From: John Hall [REDACTED]
Sent: 07 May 2019 10:25
To: Laura Gibbons
Cc: Andrew Wood; David Moore - Consulting [REDACTED]
Subject: RE: F/30/18/PL - Drainage comments

Thank you for your comments concerning our application to erect multispan polythene tunnels at Wicks Farm, Ford – F/30/18/PL.

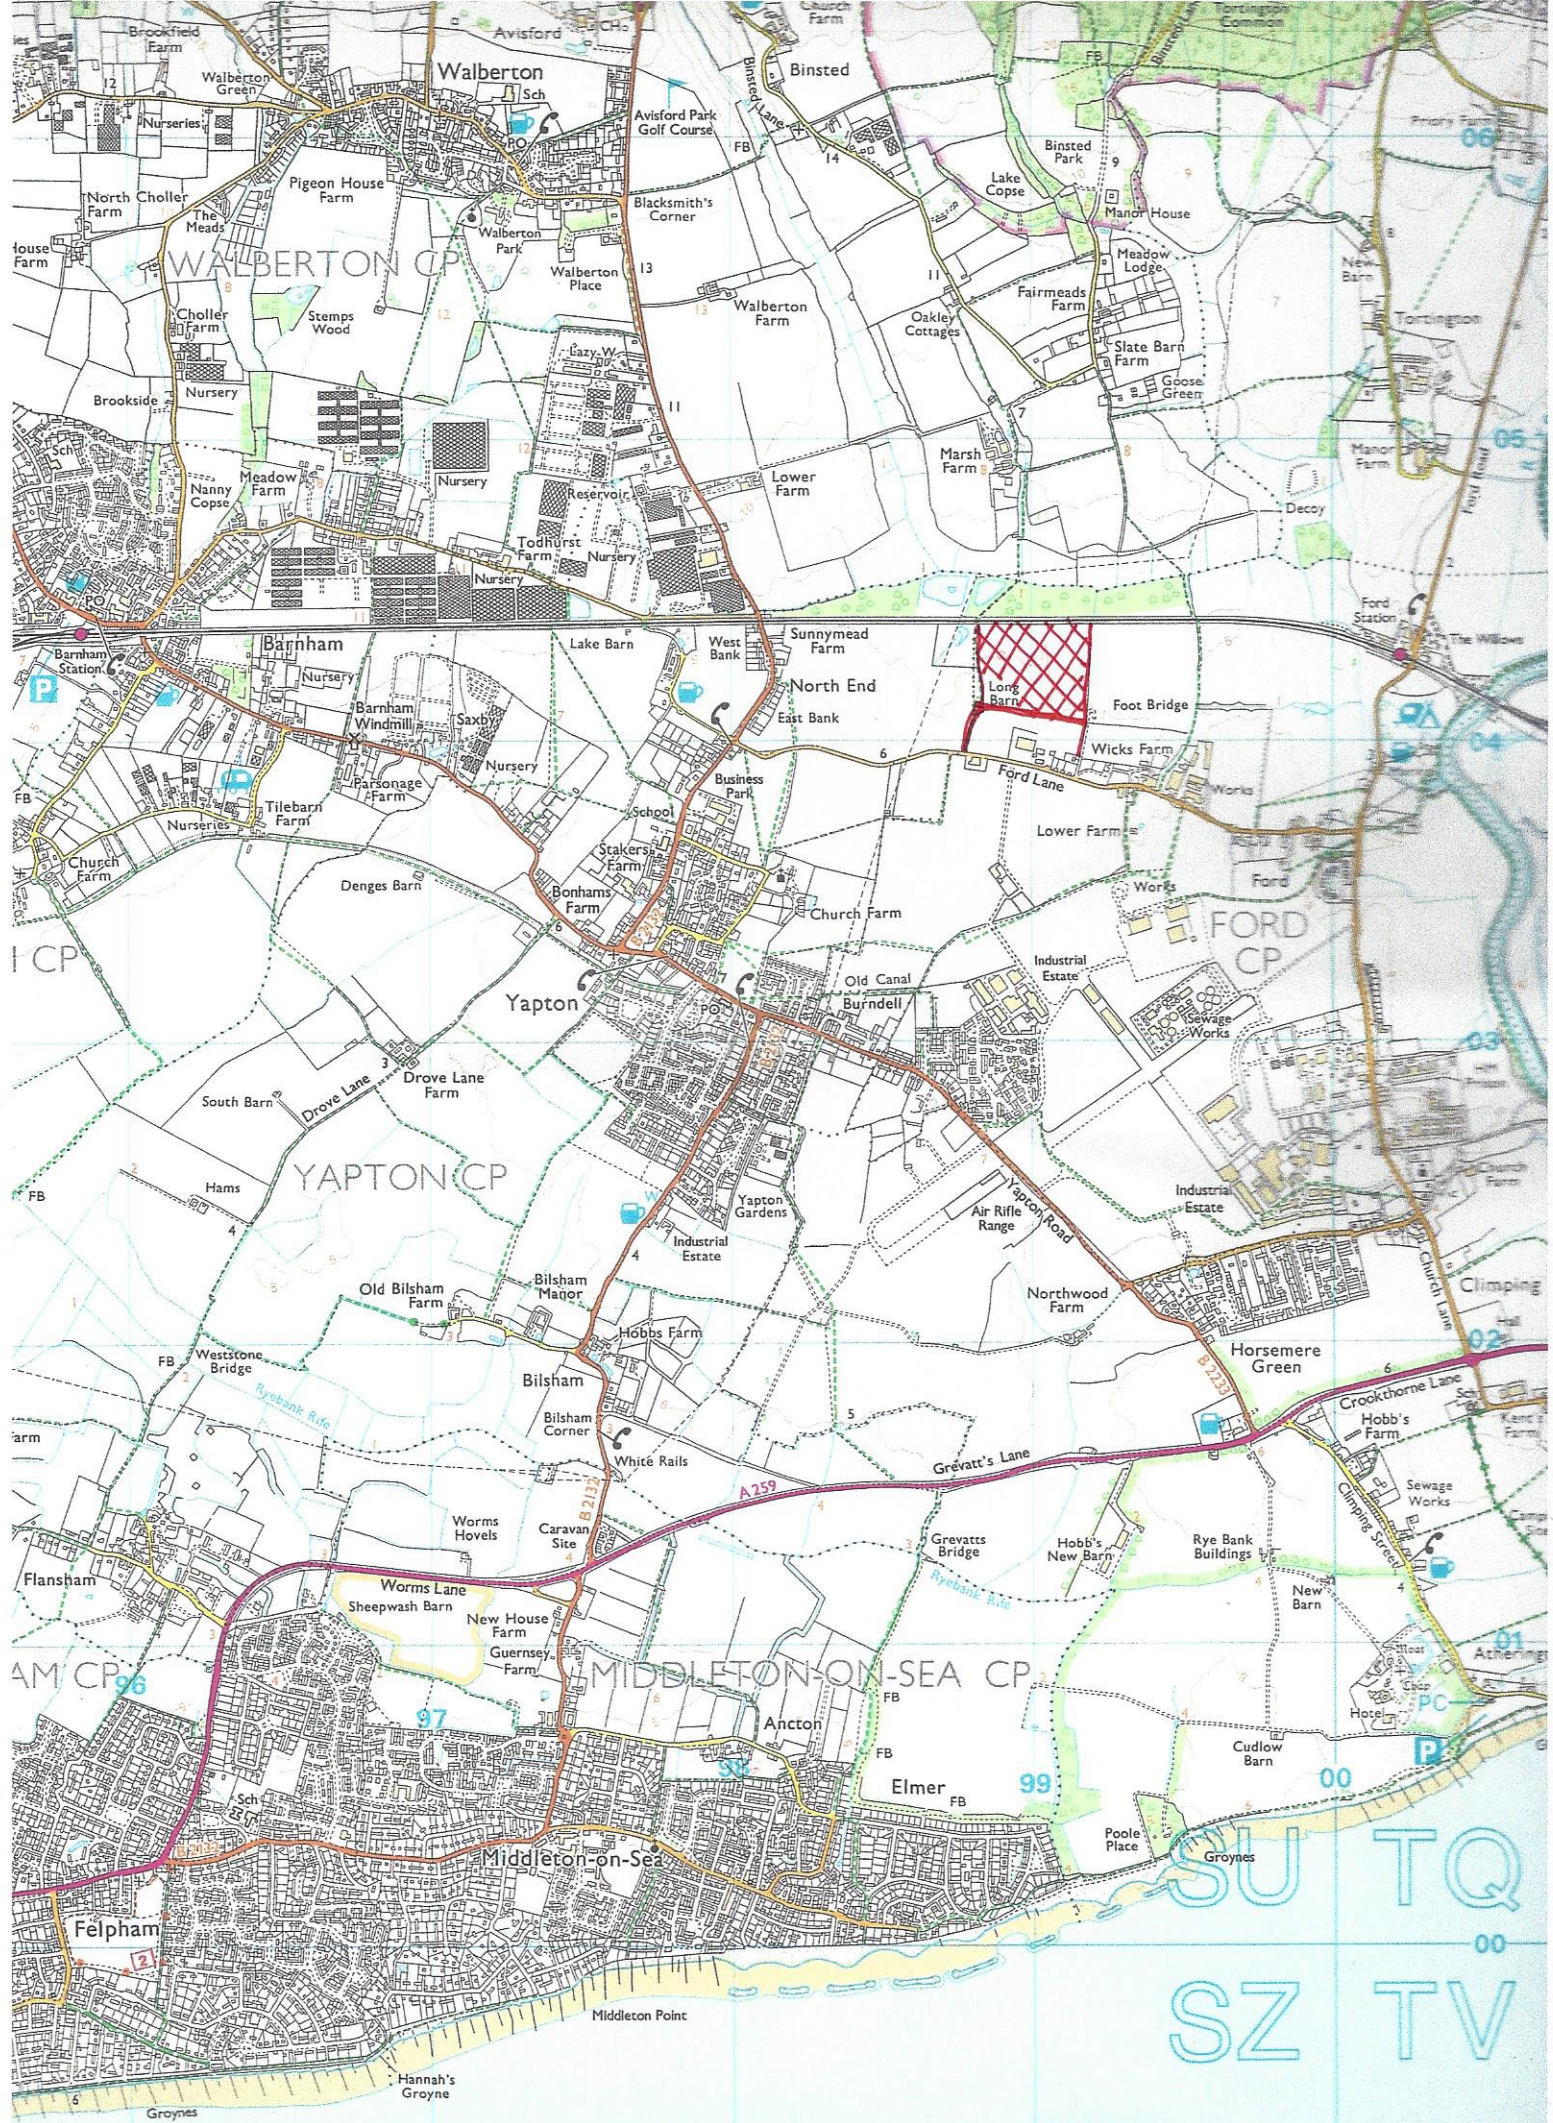
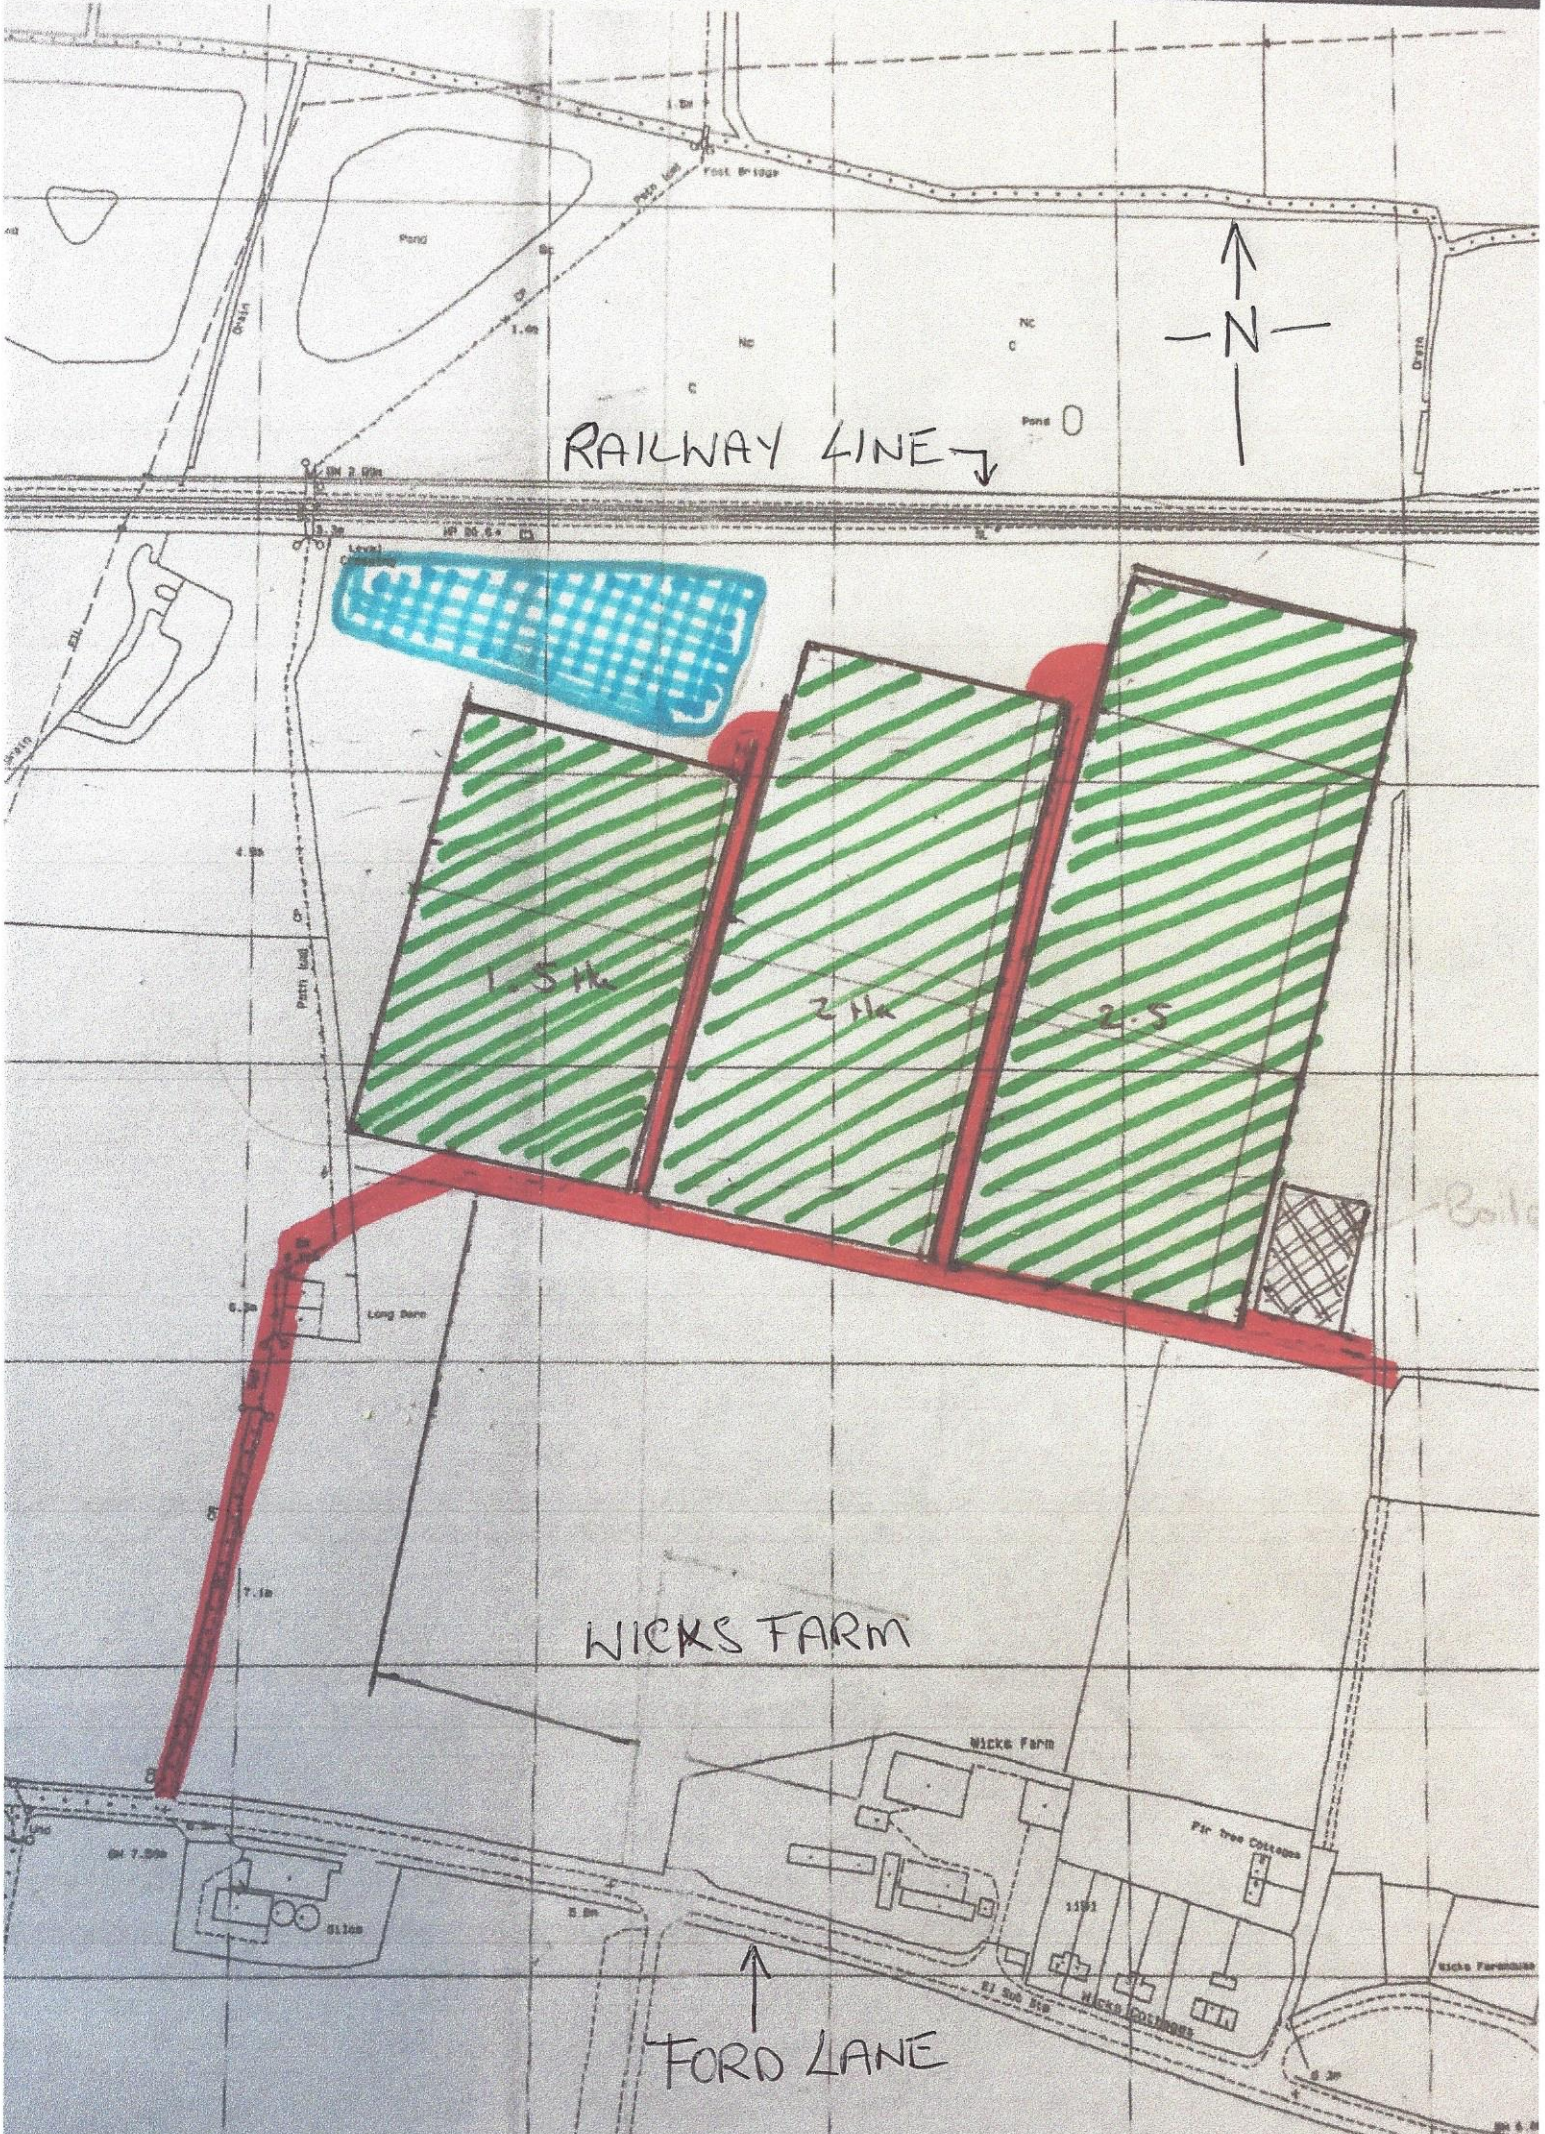
Can you please update the surface water drainage proposals to clearly show this proposed overflow to the ditch system?

And no the information is inadequate, at the minute I have no confidence that the proposals will not increase flood risk elsewhere, including the PRoW. Clarification of where the surface water is discharging would be a good start. Proposed levels across the site would also be of benefit.

The overflow from the proposed reservoir at Wicks Farm will discharge into the ditch that runs along the Northern boundary of the field. This ditch joins the major drainage channel at Ford before passing under the Ford Road and then directly into the River Arun.

The Access & Design Statement explains and the technical drawing shows that all the rain water falling on the multispan polythene tunnels will drain North to the new reservoir planned for the lowest part of the field. An overflow system will be designed to take surplus water to the existing local ditch system and onward directly to the River Arun.

SECTION B-B - POND OVERFLOW DRAINAGE PIPE
(SCALE 1:50)

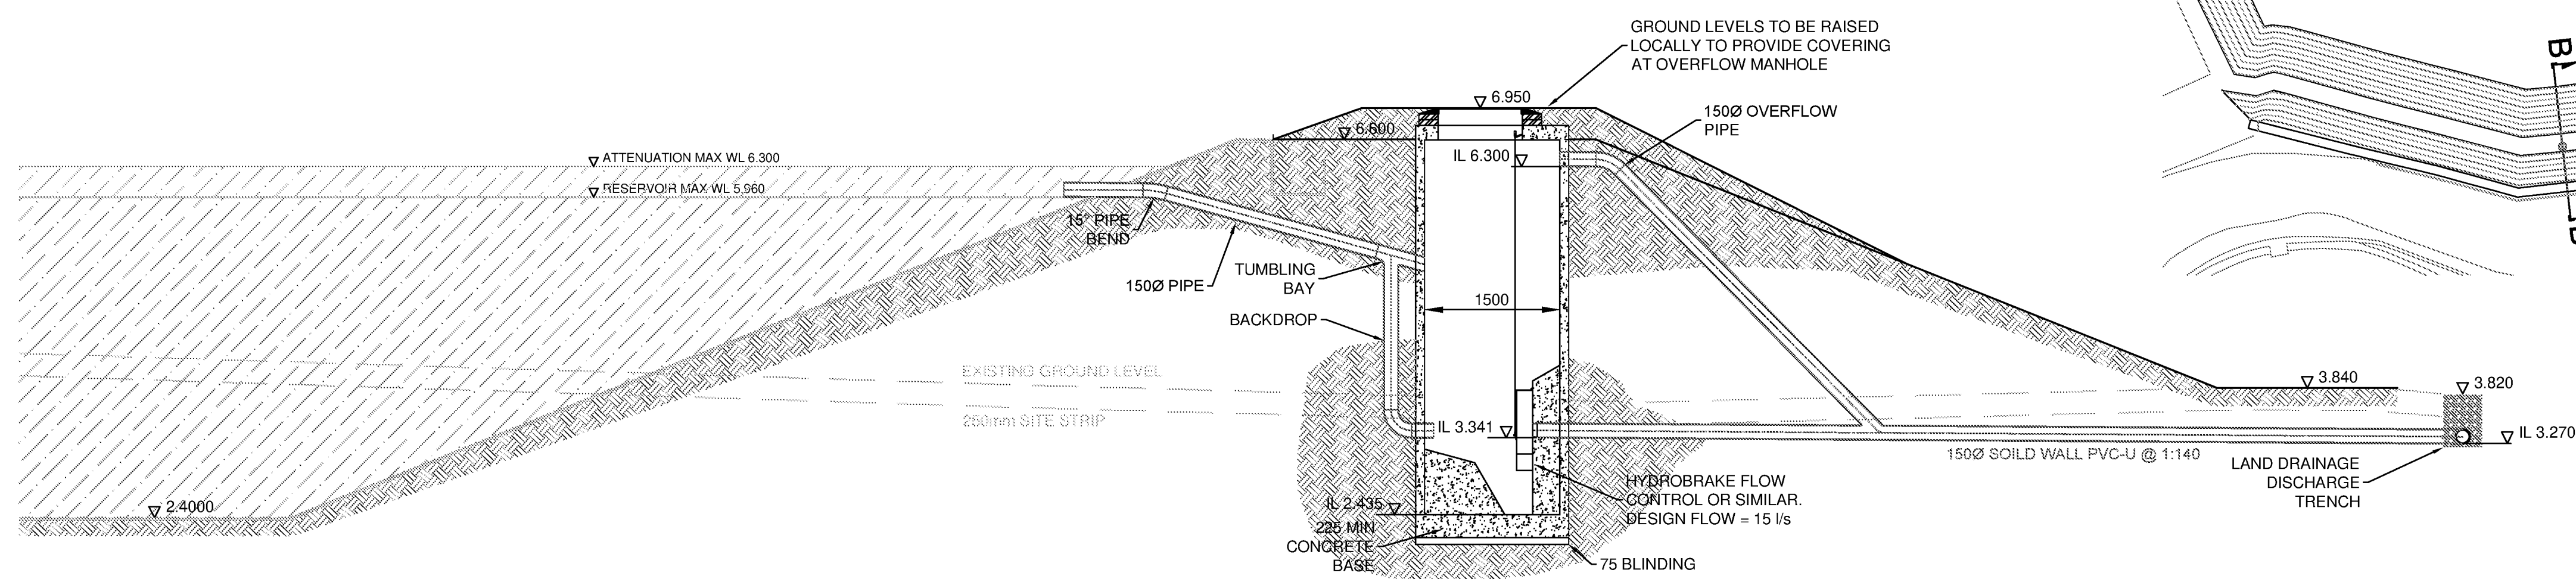
My main concern is the location of this proposed overflow. I.e. which watercourse are you discharging to and where? Without this information the fundamental concepts cannot be agreed.

I don't yet have the detailed design drawings for the proposed new reservoir at Wicks Farm; so I can't show you the detail of the overflow system; however; I'm attaching a copy of the design plans that we used for the new reservoir at Seftor Farm, Pagham. We completed that build in November 2018 and I've also attached a photo of the completed reservoir.
